**EL PASO COUNTY PLANNING AND
 COMMUNITY DEVELOPMENT
 DEPARTMENT**

GRADING AND EROSION CONTROL PLAN CHECKLIST

PPR 000

EL PASO COUNTY, STATE OF COLORADO
GRADING & EROSION CONTROL PLAN

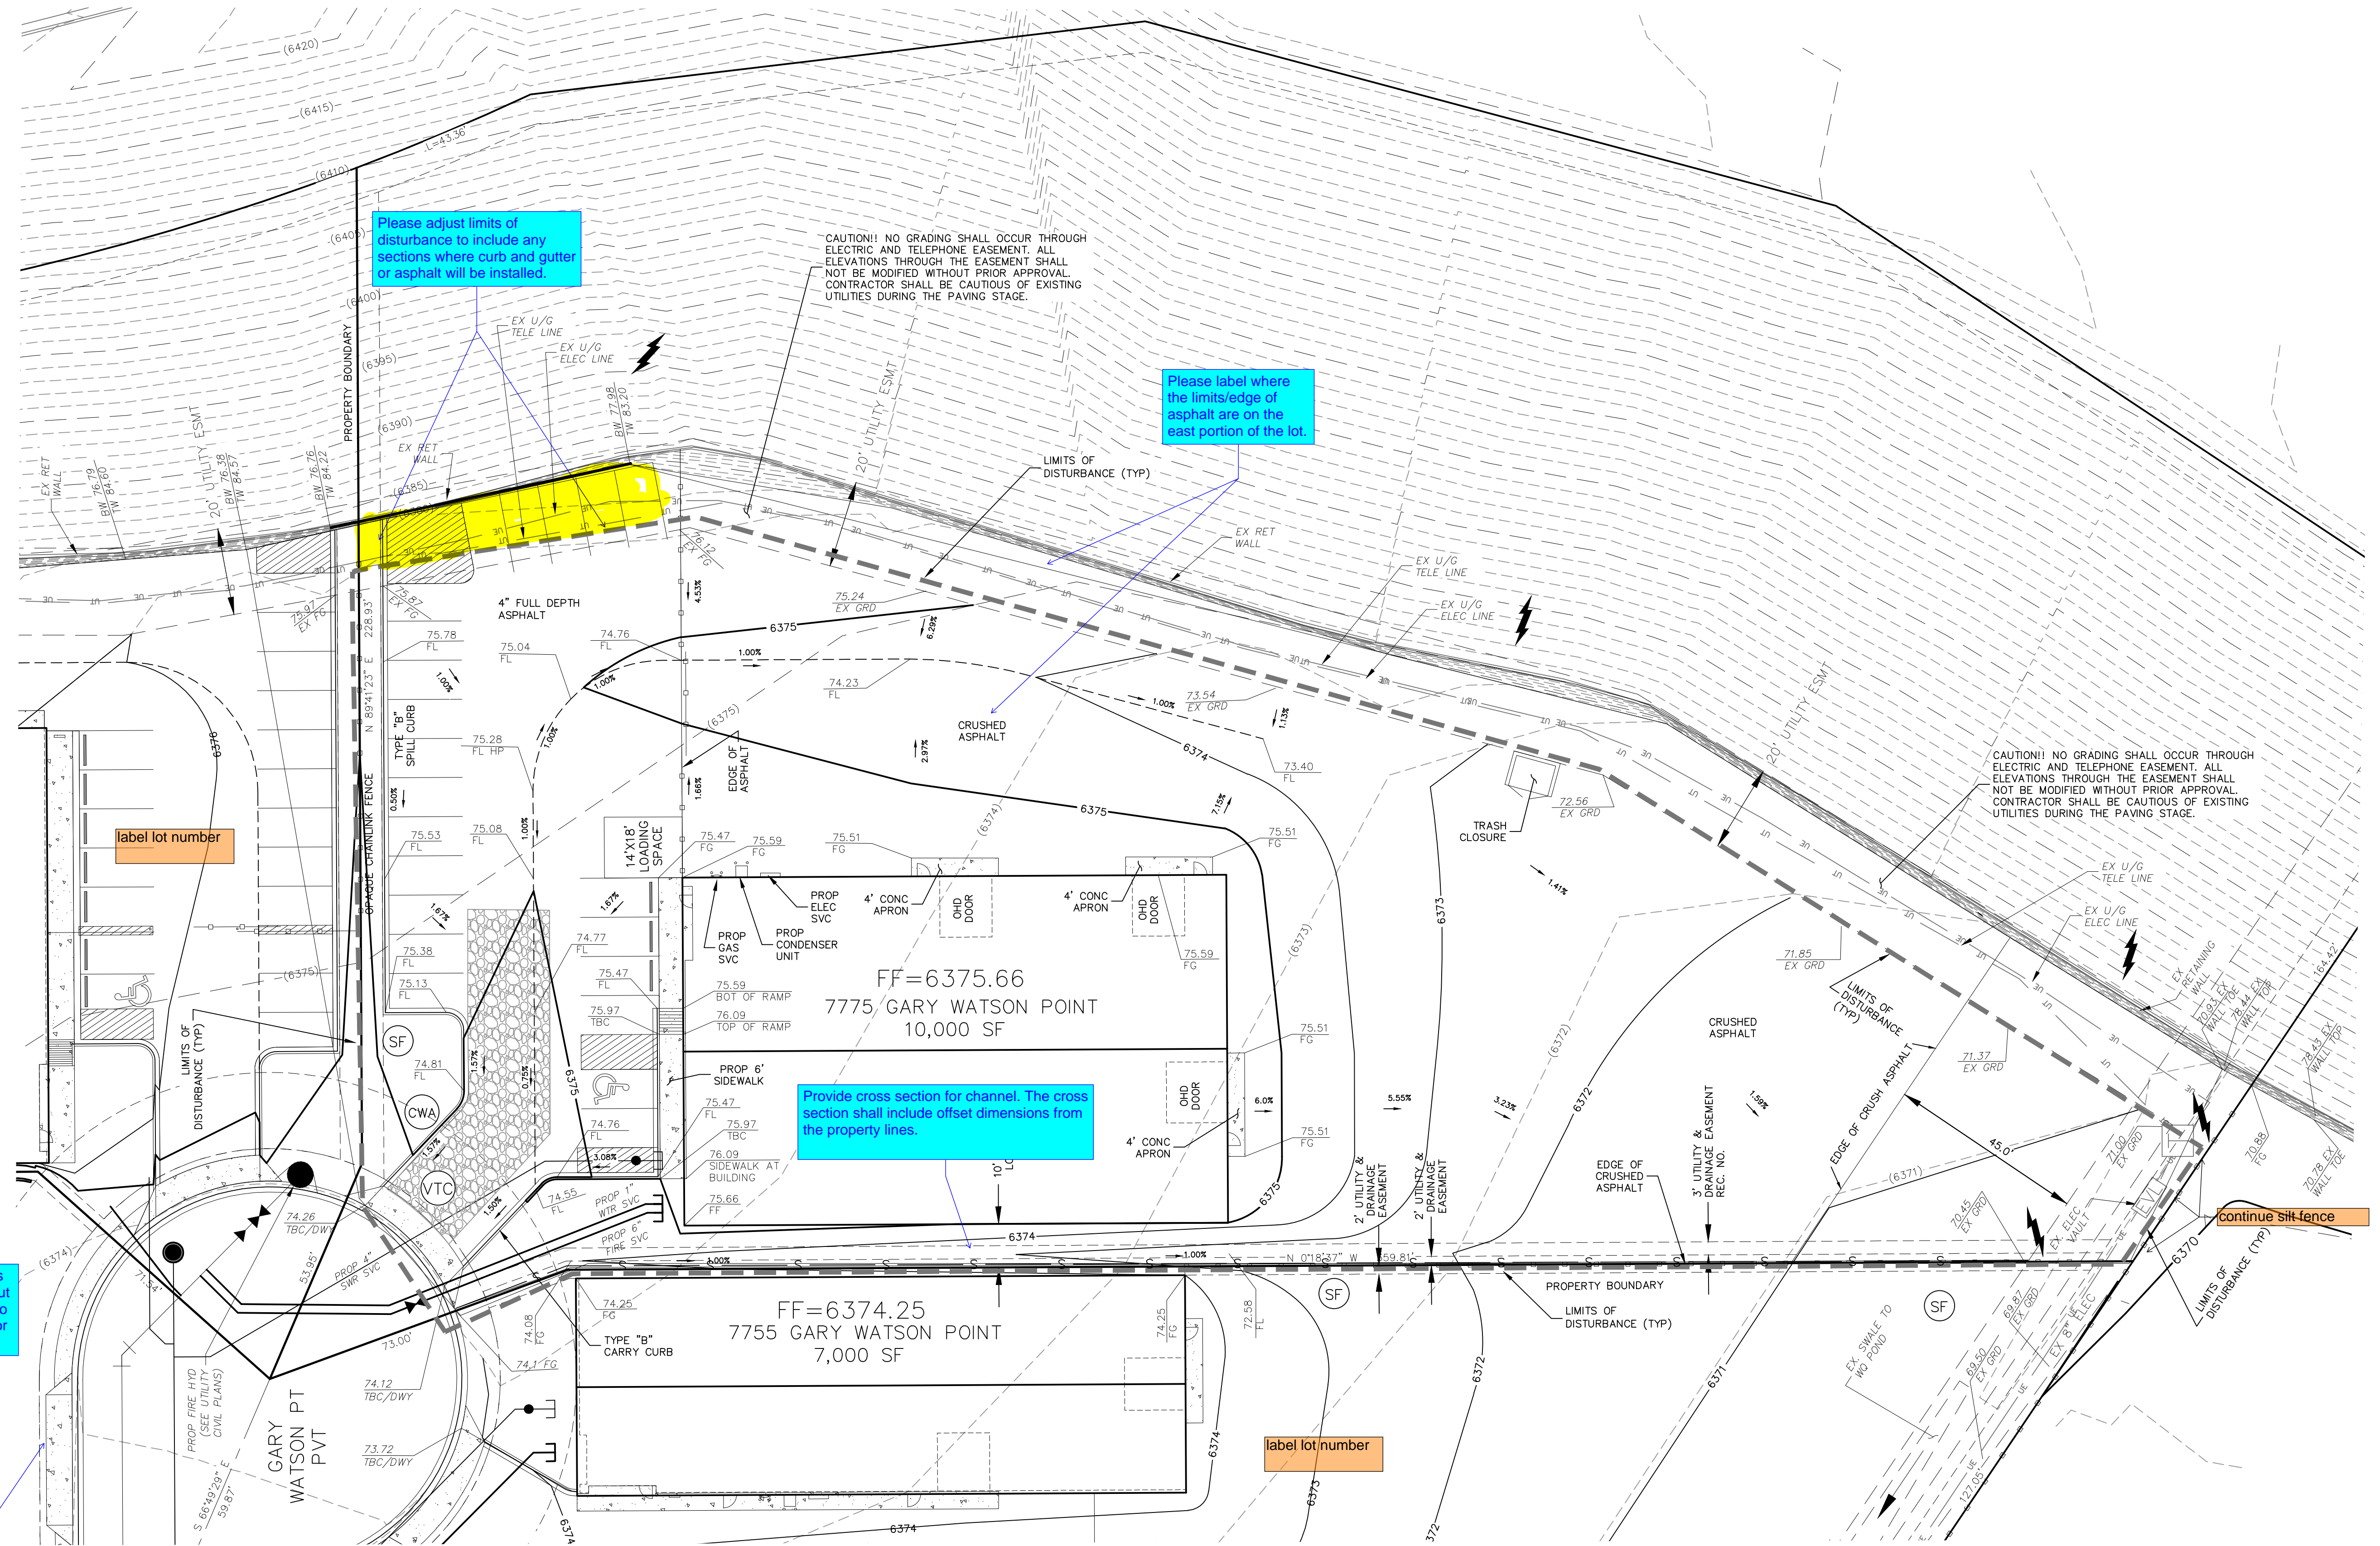
✗ Needs to be addressed

Applicant	PCD
1. GRADING AND EROSION CONTROL PLAN			
a	Vicinity map.	X	✓
b	Adjacent city/town/jurisdictional boundaries, subdivision names, and property parcel numbers labeled.	X	✗
c	North arrow and acceptable scale (1"=20' to 1"=100').	X	✓
d	Legend for all symbols used in the plan.	X	✓
e	Existing and proposed property lines. Proposed subdivision boundary for subdivision projects.	X	✓
f	All existing structures.	X	✓
g	All existing utilities.	X	✓
h	Construction site boundaries.	X	✗
i	Existing vegetation (notes are acceptable in cases where there is no notable vegetation, only grasses/weeds, or site has already been stripped).	X	✗
j	FEMA 100-yr floodplain.	N/A	N/A
k	Existing and proposed water courses including springs, streams, wetlands, detention ponds, stormwater quality structures, roadside ditches, irrigation ditches and other water surfaces. Show maintenance of pre-existing vegetation within 50 feet of a receiving water.	N/A	N/A

v	All proposed temporary construction control measures, structural and non-structural. Temporary construction control measures shall be identified by phase of implementation to include "initial," "interim," and "final" or shown on separate phased maps identifying each phase.	X	✗
w	Vehicle tracking provided at all construction entrances/exits. Construction fencing, barricades, and/or signage provided at access points not to be used for construction.	X	✓
x	Temporary sediment ponds provided for disturbed drainage areas greater than 1 acre.	N/A	✗
y	Dewatering operations to include locations of diversion, pump and discharge(s) as anticipated at time of design.	N/A	N/A
z	All proposed temporary construction control measure details. Custom or other jurisdiction's details used must meet or exceed EPC standards.	X	✓
